Recommendation Report for Planning Permission for Works or Extension to a Dwelling

REF NO: M/115/21/HH

LOCATION: 1 Sea Close
Elmer
Middleton-On-Sea
PO22 7RU

PROPOSAL: Erection of single storey rear extension

DRAWING No
364/04

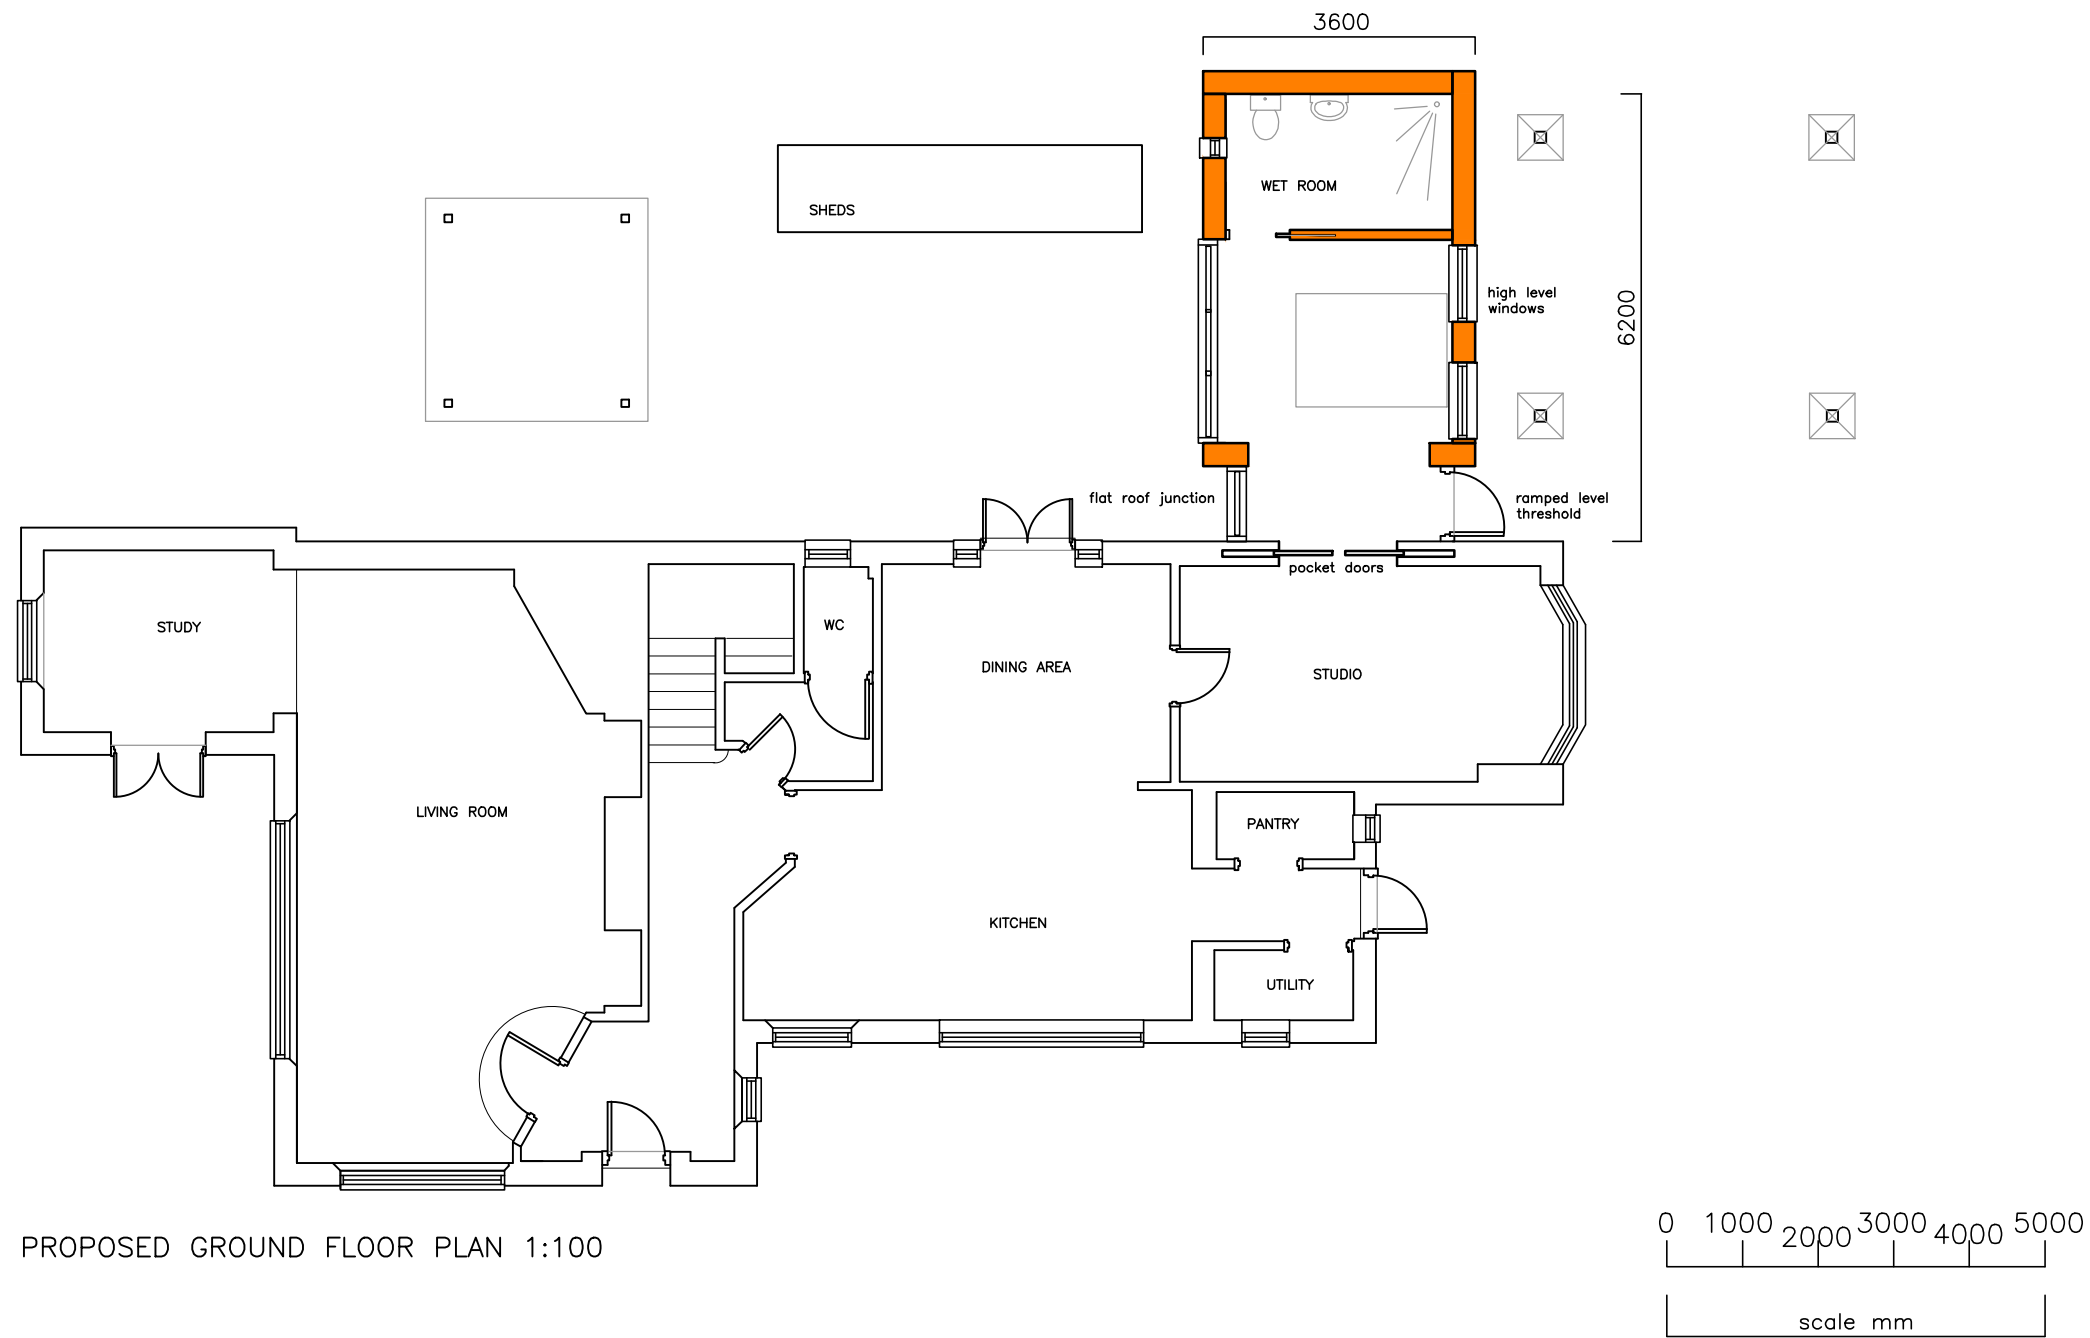
The proposal seeks to provide a single-storey rear extension protruding from the northern elevation. The amount of habitable space provided by the development is deemed appropriate when considered against the existing dwelling and the plot.

The 45-degree rule is not applicable to this extension due to the irregular size and shape of the plots. Although the extension does reduce the separation distance between the dwelling and its neighbours to the north an approximate distance of 14m will be retained, it is noted that the boundary between dwellings contains mature hedging and trees, as such, it is felt that the extension will barely be visible from the north.

DRAWING
**PROPOSED
ELEVATIONS**
DRAWING No
364/05
REVISION
SCALE 1:100
DATE JULY 2021
DRAWN LA
CHECKED

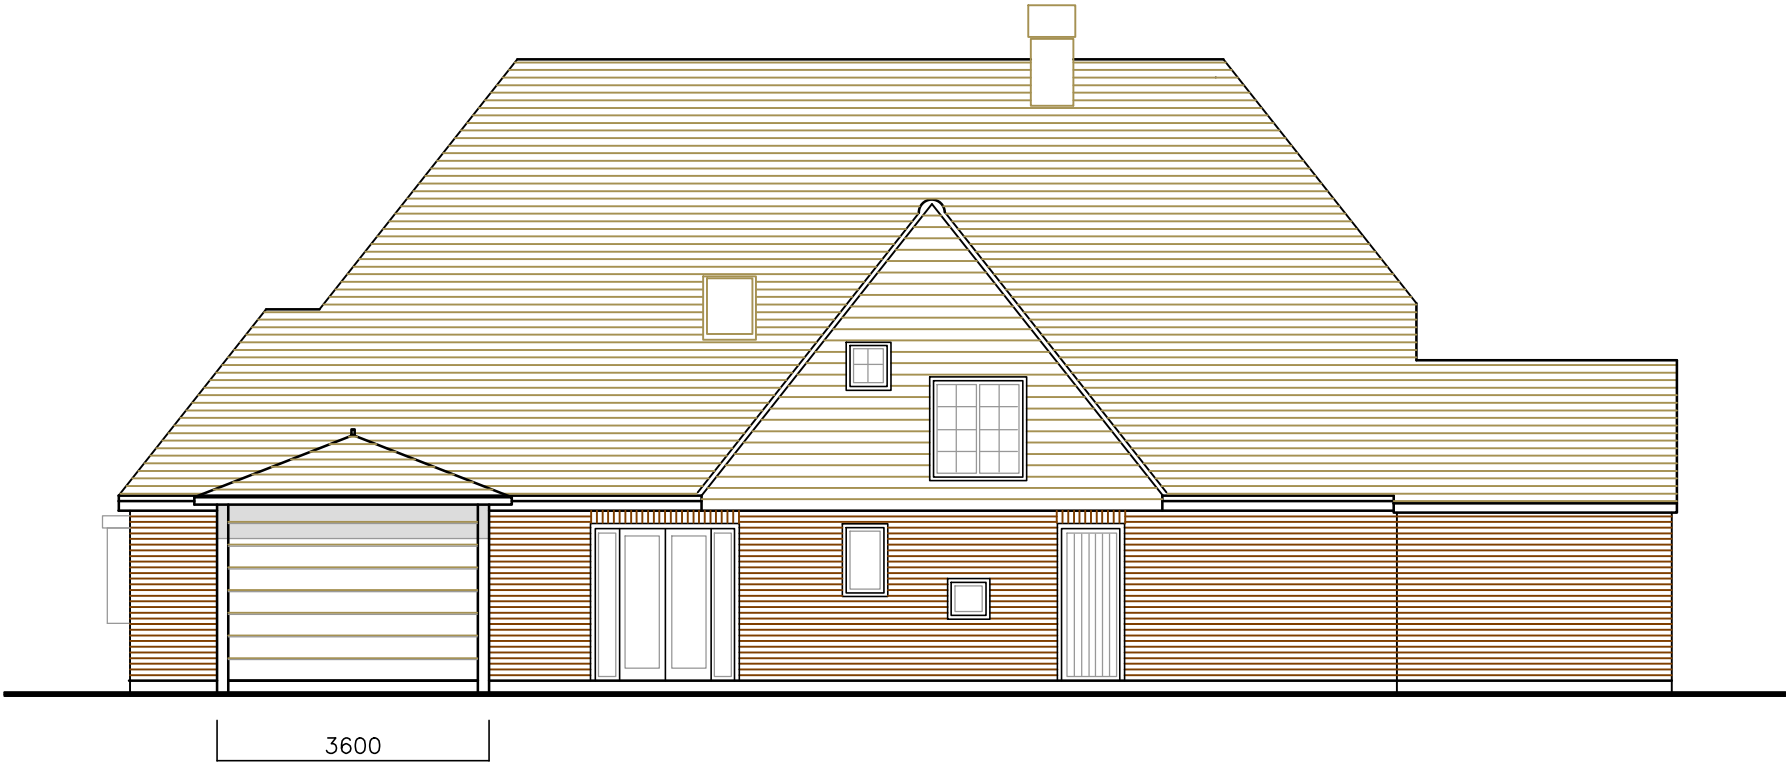
The materials to be utilised in the construction are a slight departure from the existing materials however timber weatherboarding can be found on site so there will be some element of continuity. Furthermore, design guidance states that rear extensions can have greater architectural freedom, so this is thought to be acceptable. The extension is considered an attractive addition.

Glimpses of the extension may be visible from the street, as the extension is significantly lower than the existing house and as the works are to behind primary building frontages, the extension is considered subservient to the host dwelling.

Windows are proposed to the eastern and western elevations, these face onto the private amenity space and side garden of the dwelling. No windows are proposed to the northern elevation. It is believed that only views which are already achievable will be obtained from the new fenestration.
